# Steeple Renewables Project

## Appendix 1.3 - Environment Agency EIA Scoping Response Environmental Statement - Volume 2

## Appendix 1.3 - Environment Agency EIA Scoping Response

**PLANNING ACT 2008 (AS AMENDED) AND THE INFRASTRUCTURE PLANNING  
(ENVIRONMENTAL IMPACT ASSESSMENT) REGULATIONS 2017 (THE EIA  
REGULATIONS)– REGULATIONS 10 AND 11 - SCOPING OPINION**

## Breach locations

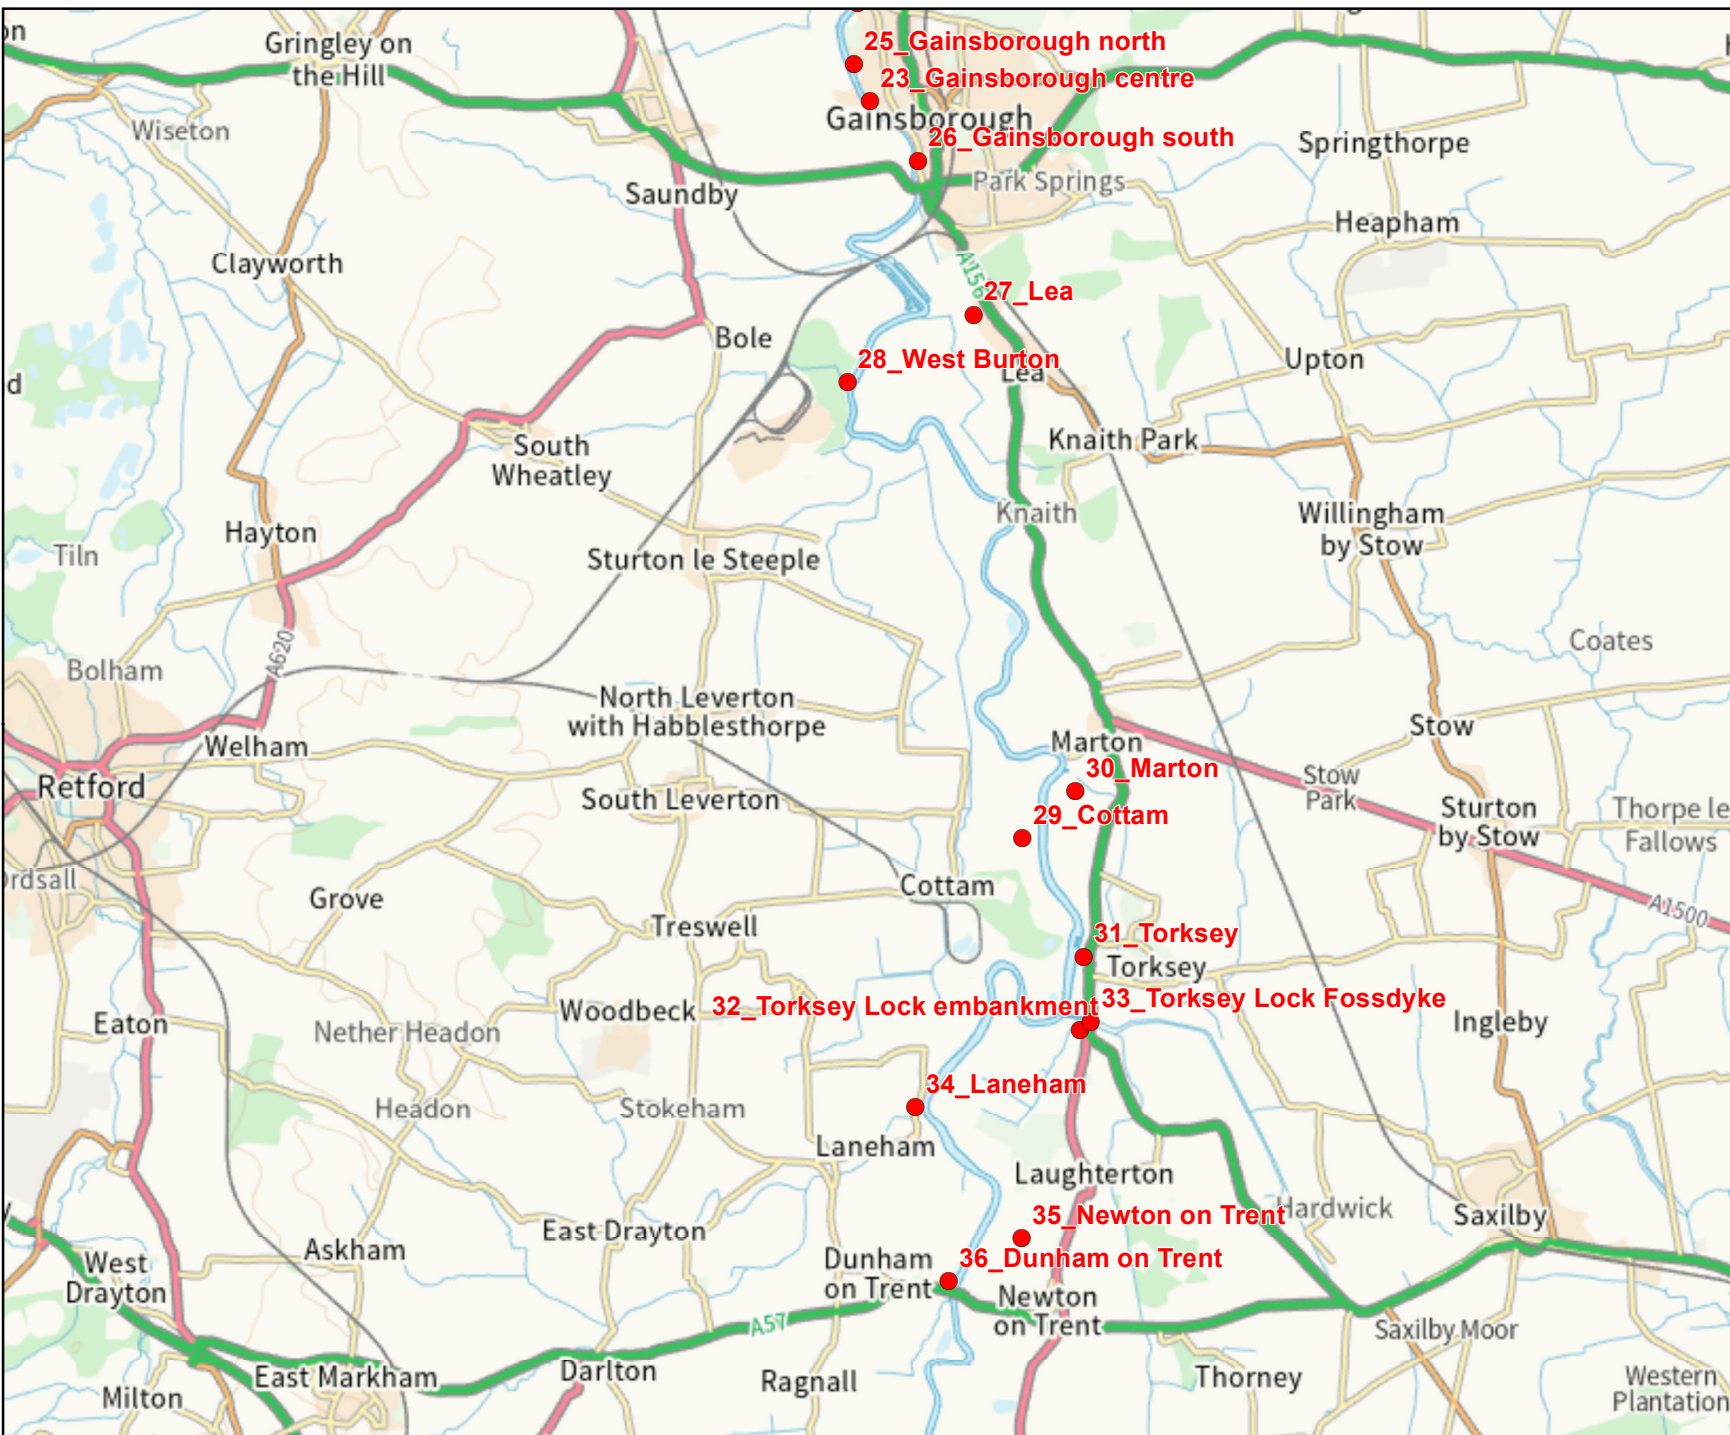
It would be sensible to consider the residual risk to the development in the event of a breach of the Trent embankments. This would not be used as a design scenario, but it would help to understand the resilience of the development were a breach in the River Trent embankments to occur. As part of the Tidal Trent modelling (Jacobs, 2023) breach runs were undertaken for the 1 in 100 year and 1 in 100 year plus central (+29%) climate change scenarios. The nearest breaches to the development site are breach 28 West Burton and Breach 29 Cottam. New breach runs may be required considering the location of the existing breaches (28 and 29) in relation to the proposed development site.

TYPICAL SPAN BRIDGE 1

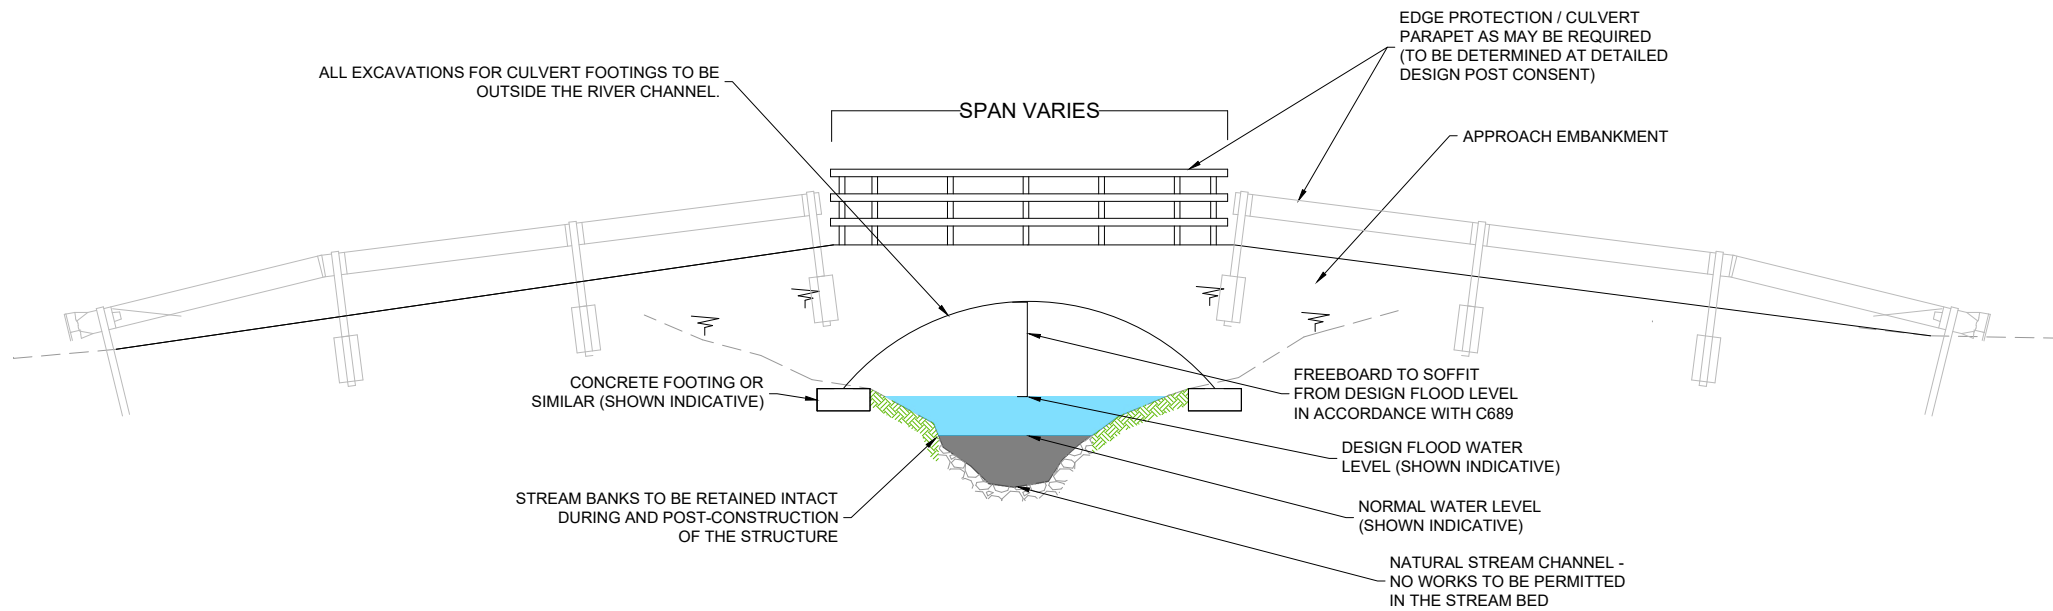
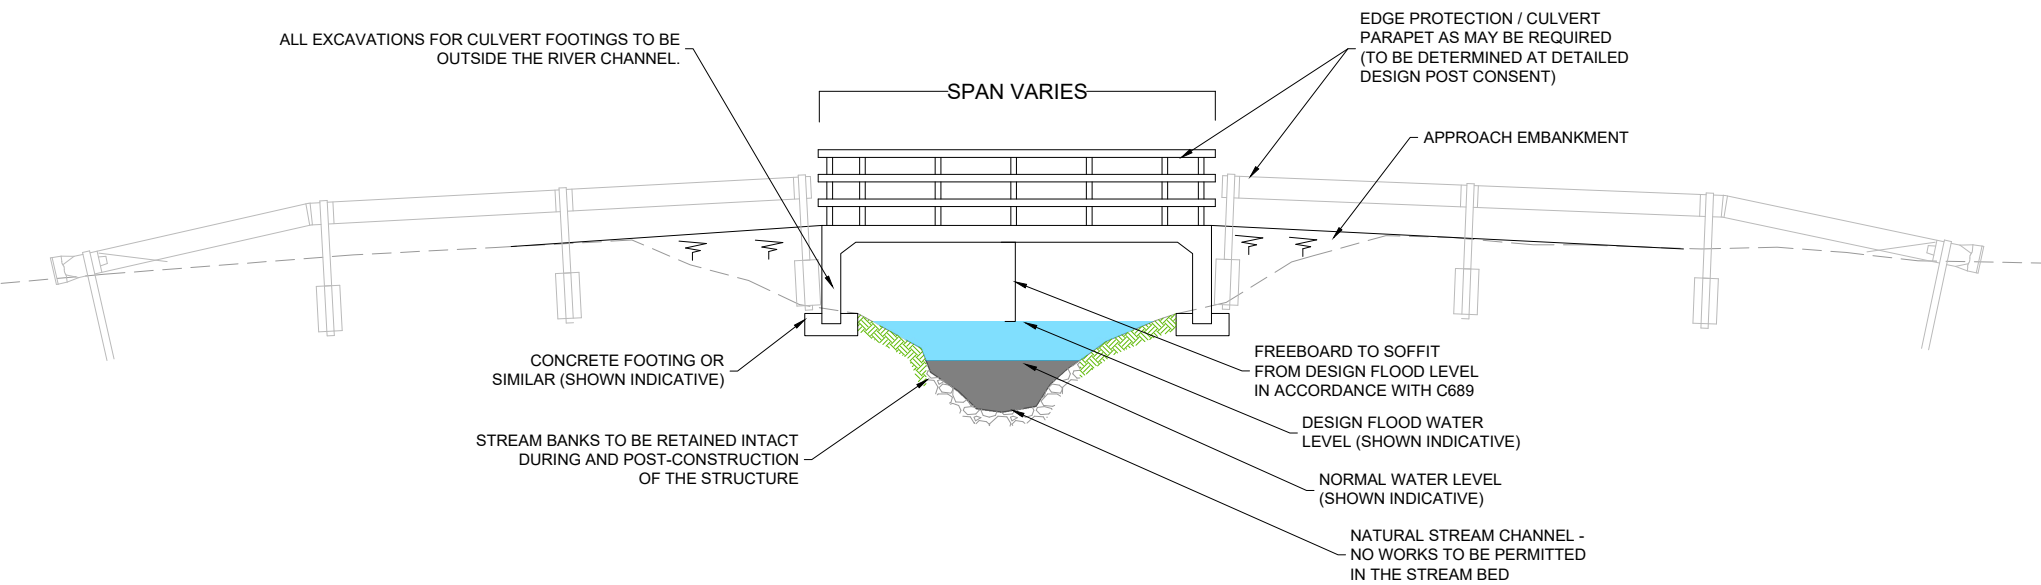
Any culverting of a watercourse or waterbody that contains fish can impact on lifecycle migration, both locally and more long distant. Culverting also impacts on fish habitat and spawning habitat by decreasing the quality of substrate. Therefore, we are opposed to the culverting of any watercourse and would prefer the installation of a clear full span crossing that maintains the natural substrate and allows free passage of fish.

The Scoping Report suggests that river crossings (bridges, culverts, and buried cables) may be required as part of this development. Therefore, we would expect to see geomorphologically robust designs that will cause minimal impacts on natural fluvial processes operating in the river/floodplain environment over the course of the 21<sup>st</sup> century.
